# KITTITAS COUNTY DEPARTMENT OF PUBLIC WORKS

TO: Jeff Watson, Community Development Services  
FROM: Christina Wollman, Planner II *CW*  
DATE: October 12, 2011  
SUBJECT: Marhel BL-11-00020

The Public Works Department has reviewed the Request for Boundary Line Adjustment Application. In order to ensure that it meets current Kittitas County Road Standards, the applicant needs to provide the following prior to final approval:

# BOUNDARY LINE ADJUSTMENT A PORTION OF THE WEST HALF OF SECTION 14, T.17N., R.20E., W.M., KITTITAS COUNTY, WASHINGTON.

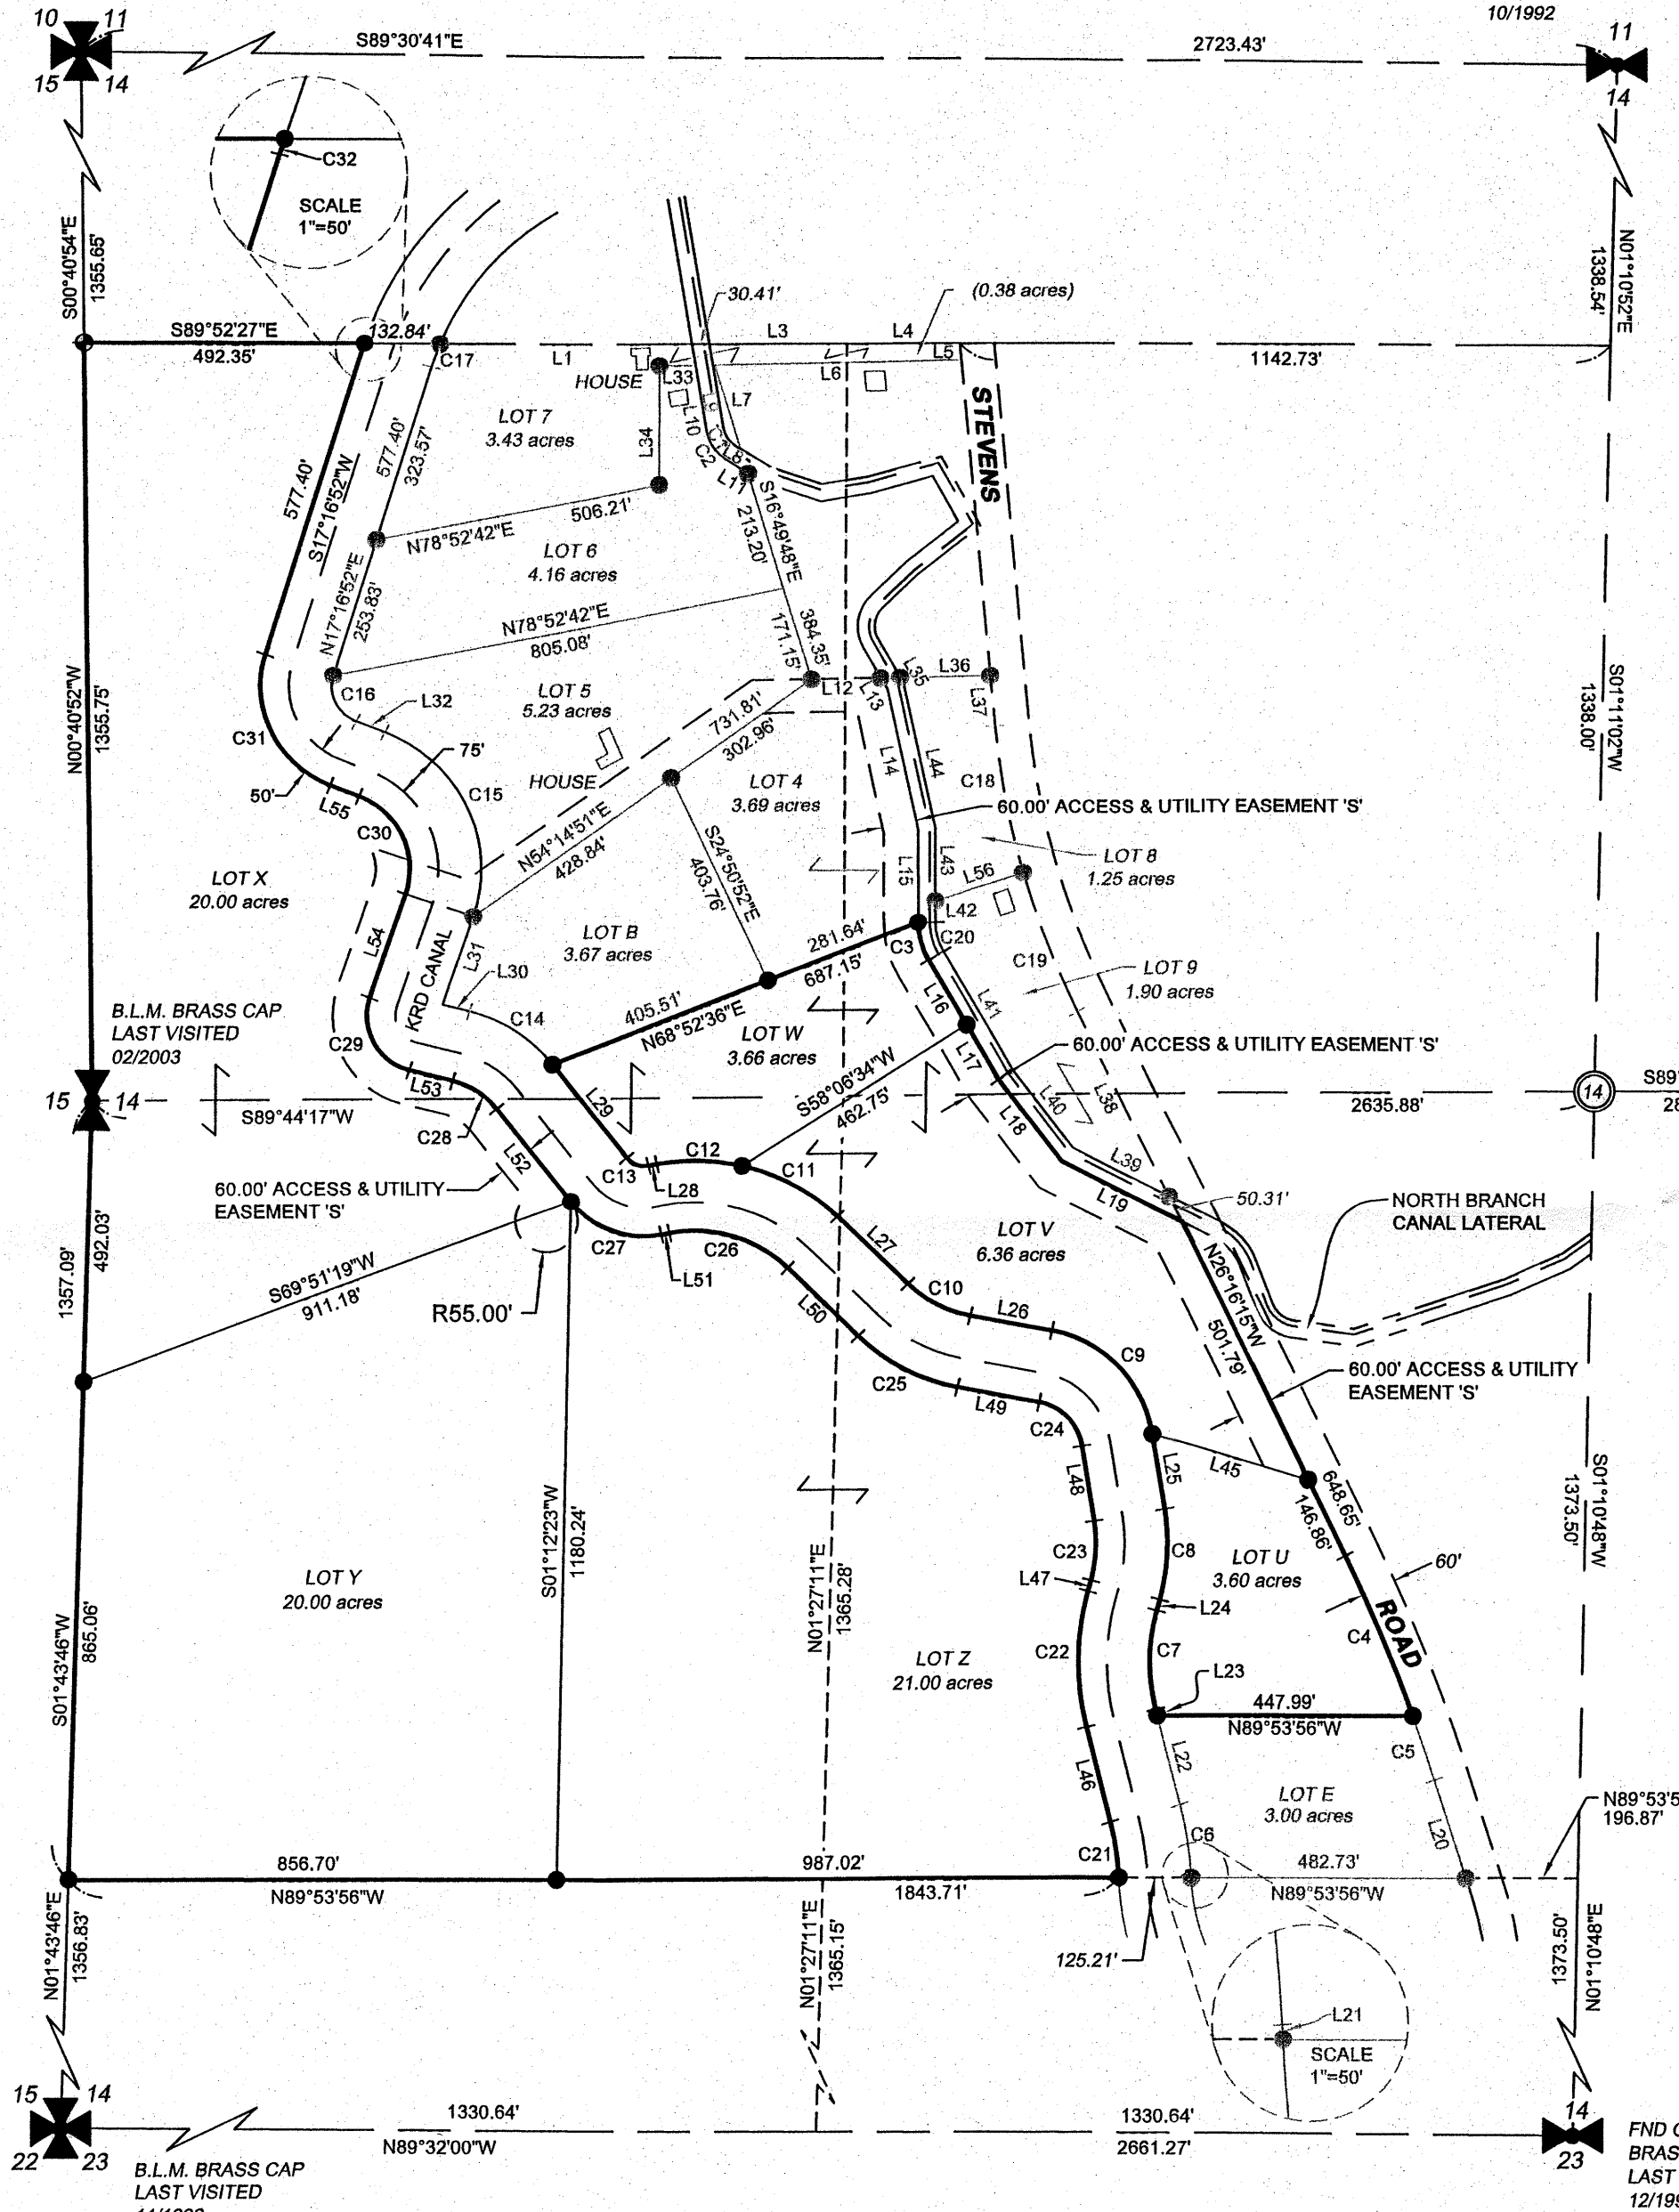
1. The easements shown on the proposed survey do not correspond to the plans of the applicant, per email from Dave Nelson. The actual proposed access with appropriate easement(s) shall be shown and shall conform to applicable Kittitas County Road Standards.

I'm reviewing the Marchel BLA and it looks like the access to the back lots changed and is now coming across Harold Holmes' property. Is this correct? If so, I'll need an easement across the Holmes property before I can grant final approval. And Stevens Road has a spacing requirement of 300'. The location where this access appears to be is only 180' from the approach to the south and 150' from the approach to the north.

THE EASEMENT THAT SHOWS UP ON THE SURVEY IS AN OLD EASEMENT THAT CROSSES LOT 8 NOT HAROLD HOLMES PROPERTY. THE EASEMENT THAT WE ARE USING SHOULD RUN ALONG THE WEST SIDE OF THE IRRIGATION DITCH TO THE WEST OF LOTS 8 & 9 AS SHOWN ON THAT CERTAIN SURVEY RECORDED IN BOOK 36 OF SURVEYS AT PAGE 240. ARVIN WAS SUPPOSED TO RESERVE AN EASEMENT BETWEEN LOTS 8 & 9, AND HE CLAIMS HE DID BUT I CANT FIND IT. HE ALSO CLAIMS THAT HE RESERVED AN EASEMENT ACROSS THE NORTH LINE OF LOT 8 BUT I BELIEVE HE SOLD LOT 8 BEFORE WE DID THAT EASEMENT.

FOR NOW PLEASE USE EASEMENTS "S" AND "R" AS PER BOOK 36 OF SURVEYS, PAGE 240 TO ACCESS THE LOTS AS SHOWN.
